Mountain View Electric Association, Inc. (MVEA) has these comments about the following:

Project Name: Waterbury, Filing #2

Project Number: SF-17-019

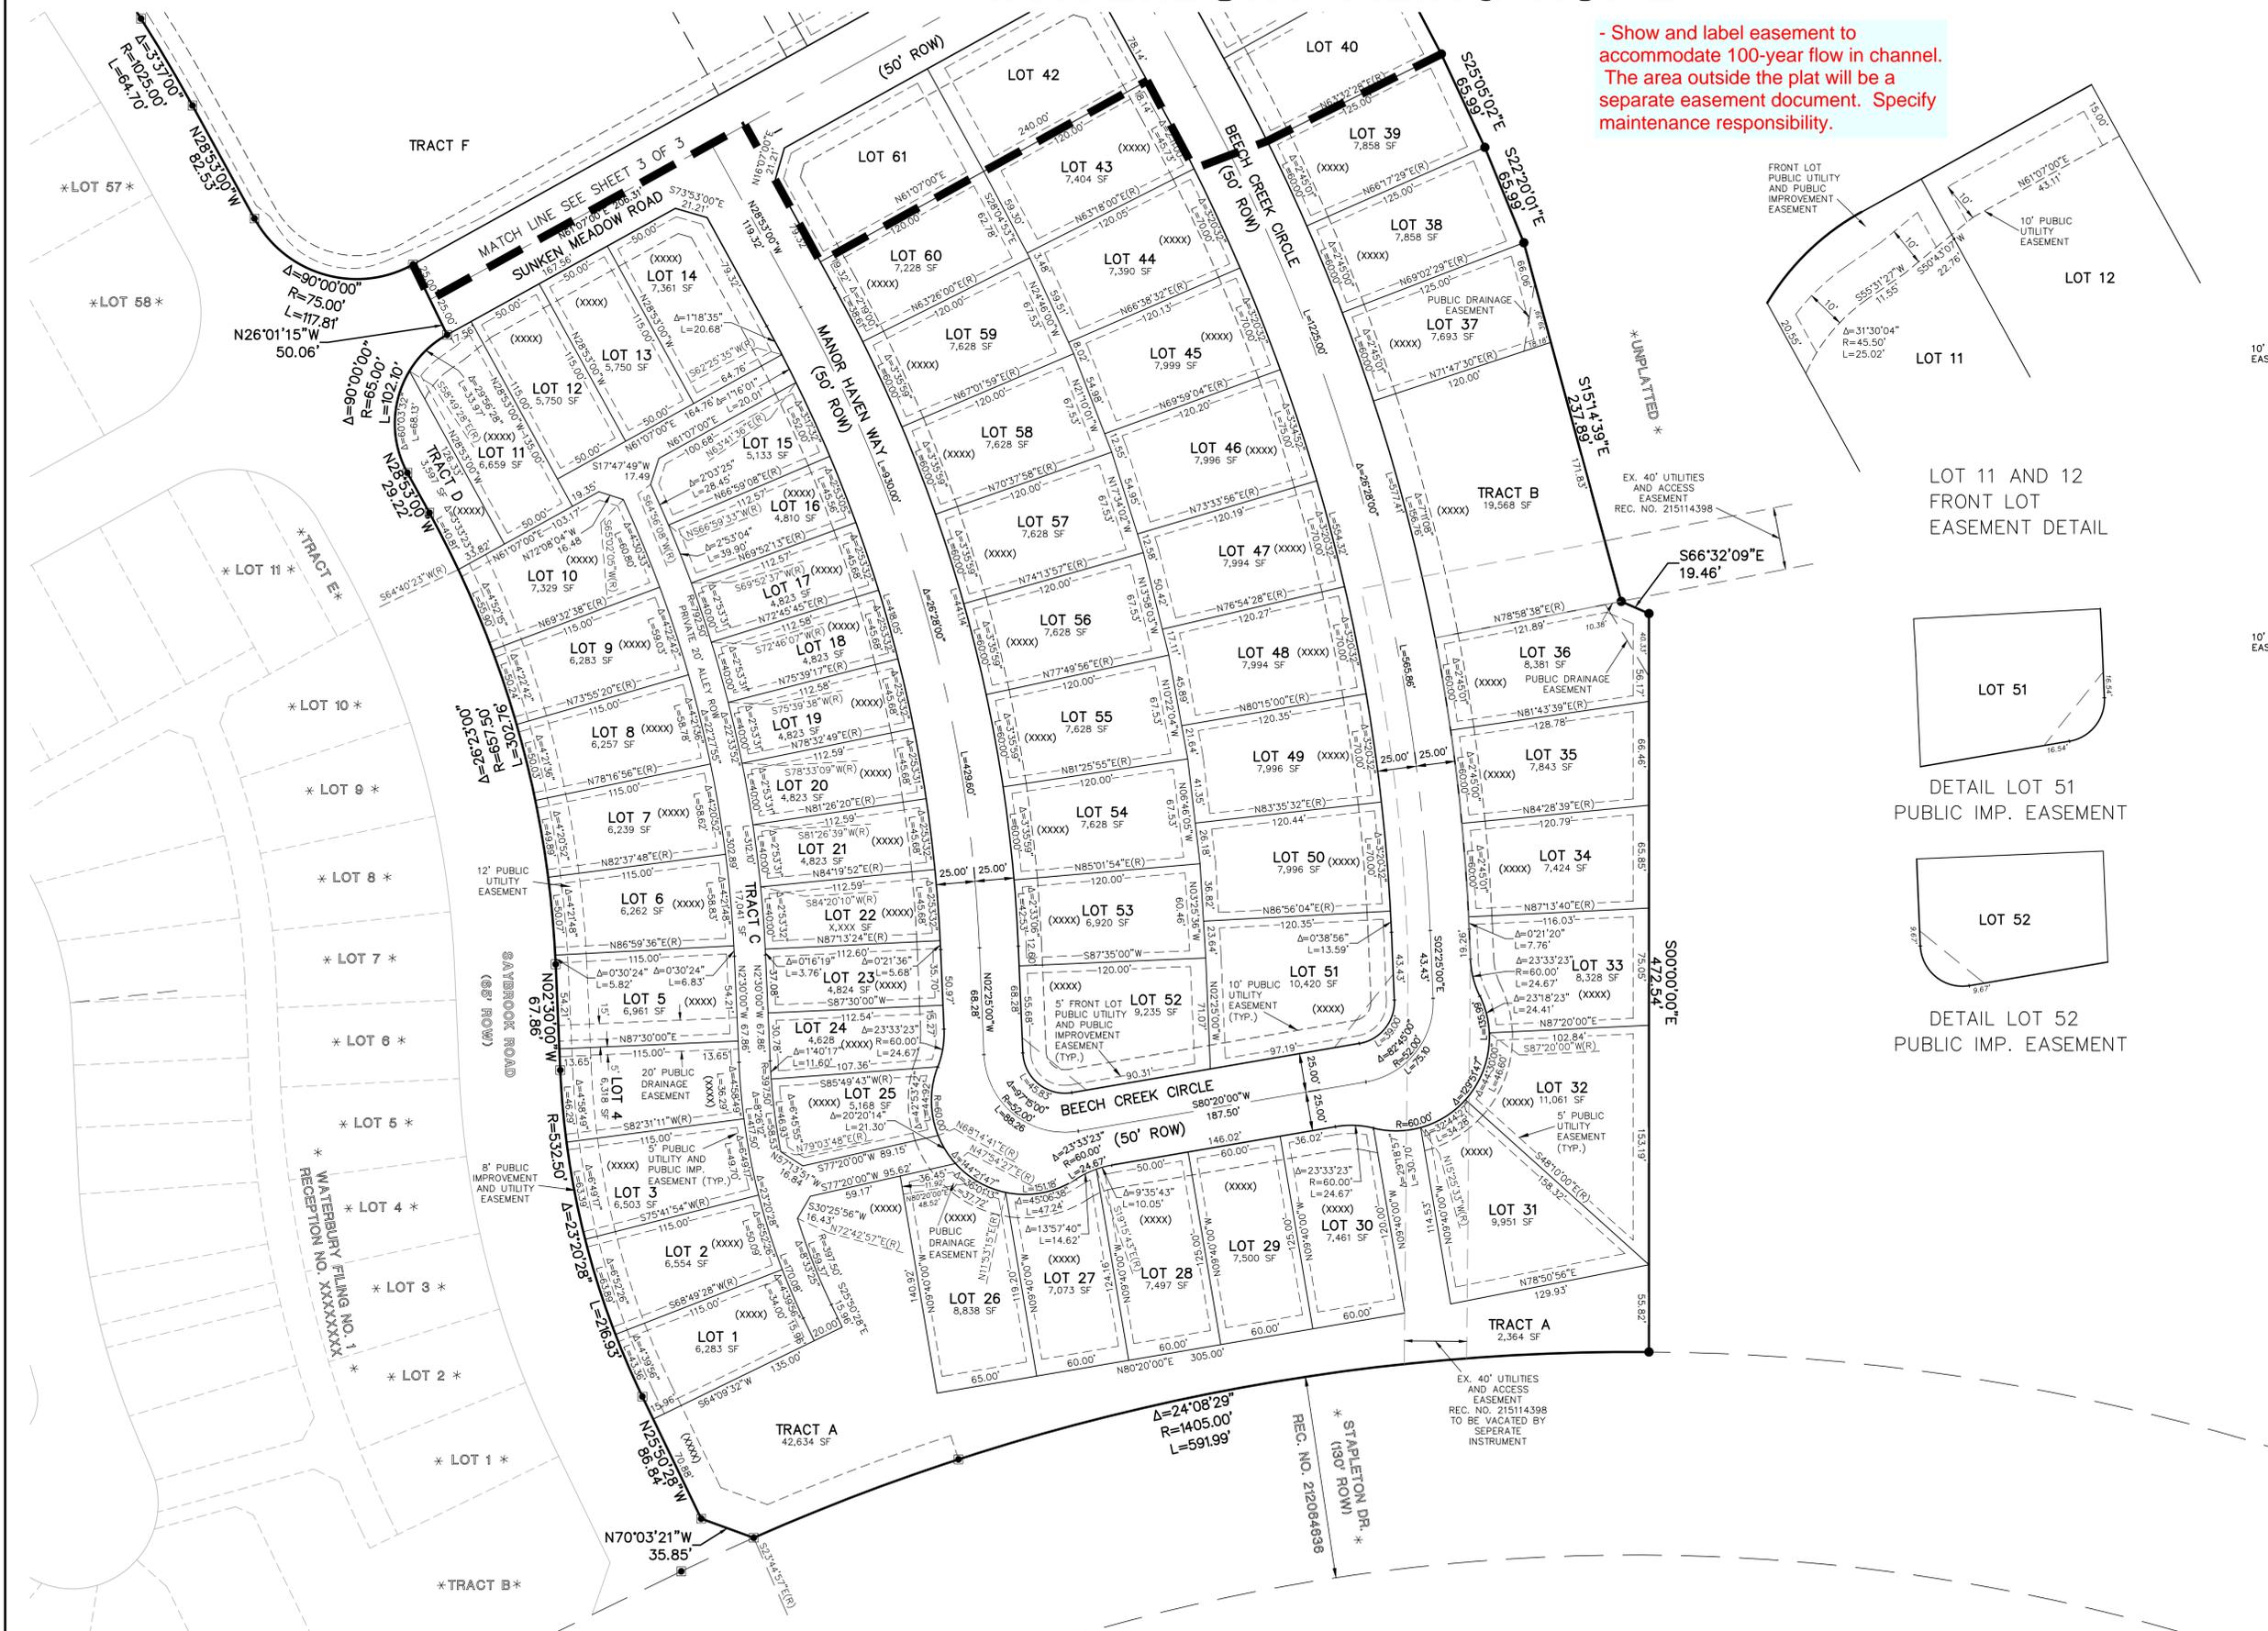
MVEA requests a ten (10) foot front, side and rear lot line utility easement along with a twenty (20) foot exterior easement on plat. If open space, drainage and landscape tracts are designed in this subdivision MVEA requests these areas be listed to include utilities.
